**Planning Department
Transportation Development Services**

Re: Valley High School
1505 Candelaria Rd., NW
Traffic Circulation Layout
Engineer's/Architect's Stamp dated 9-20-15 (G13-D010)

Based upon the information provided in your submittal received 10-20-15, the above referenced plan cannot be approved for Building Permit until the following comments are addressed:

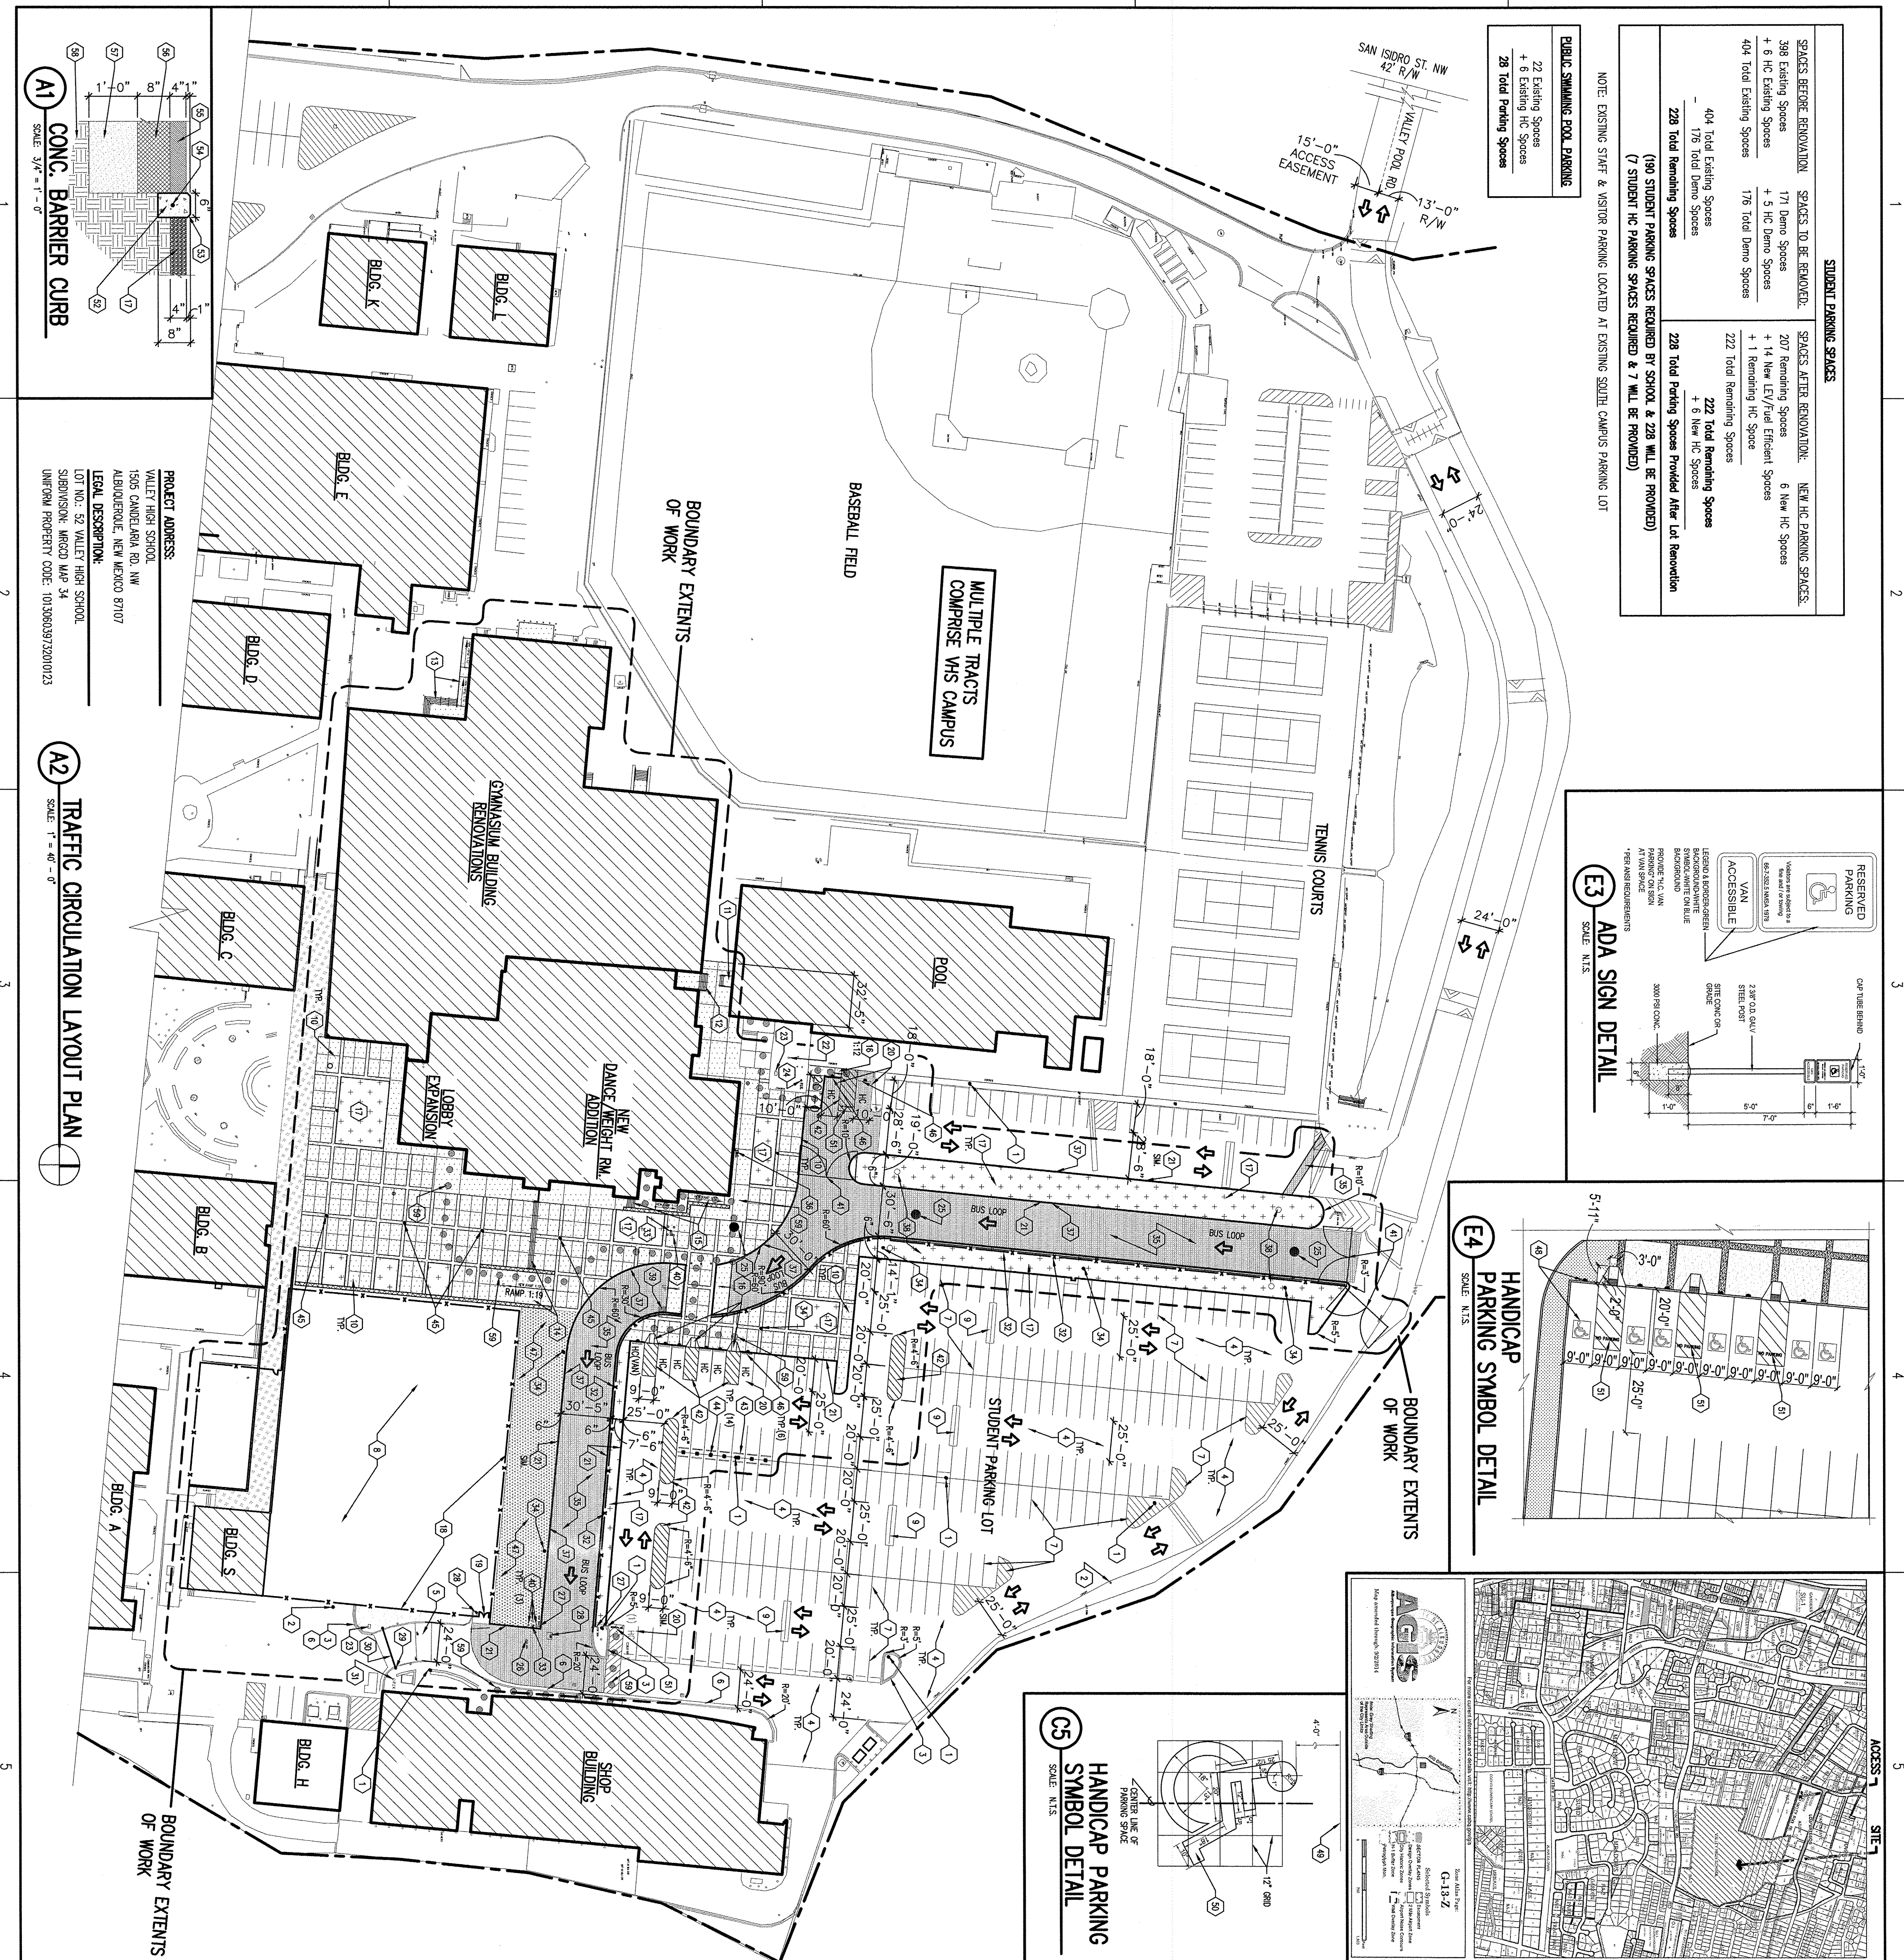
1. Please show a vicinity map showing the location of the development in relation to streets and well known landmarks.
2. Clarify the extents of the current phase.

3. Identify all existing access easements and rights of way with dimensions.
4. Identify the right of way width, medians, curb cuts, and street widths leading to the Phase I Renovation parking lot.

5. Please list the width and length for all existing and proposed parking spaces, including ADA Handicap parking spaces.
6. The handicap accessible spaces must be a minimum of 8.5 feet in width.

7. The handicap accessible spaces must include an 8-foot wide van access aisle; all other aisles should be 5 feet in width.
8. The ADA accessible parking sign must have the required language per 66-7-352.4C NMSA 1978 **"Violators Are Subject to a Fine and/or Towing."** Please show this detail on the drawing.

9. The ADA access aisle shall have the words **"NO PARKING"** in capital letters, each of which shall be at least one foot high and at least two inches wide, placed at the rear of the parking space so as to be close to where an adjacent vehicle's rear tire would be placed. (66-1-4.1.B NMSA 1978) Please show or state this detail.

10. Show all drive aisle widths and radii.

11. Per the DPM, a 6 ft. wide ADA accessible pedestrian pathway is required from the HC parking stall access aisles to the building entrances. Please clearly show this pathway to entrances from all HC parking stalls.
12. Provide a min 6" or max 8" high concrete barrier curb or other acceptable barrier between landscaping and parking areas and/or drive aisles. Please call out this detail on drawing.
13. Design delivery vehicle route needs to be shown.
14. Please include two copies of the traffic circulation layout at the next submittal.
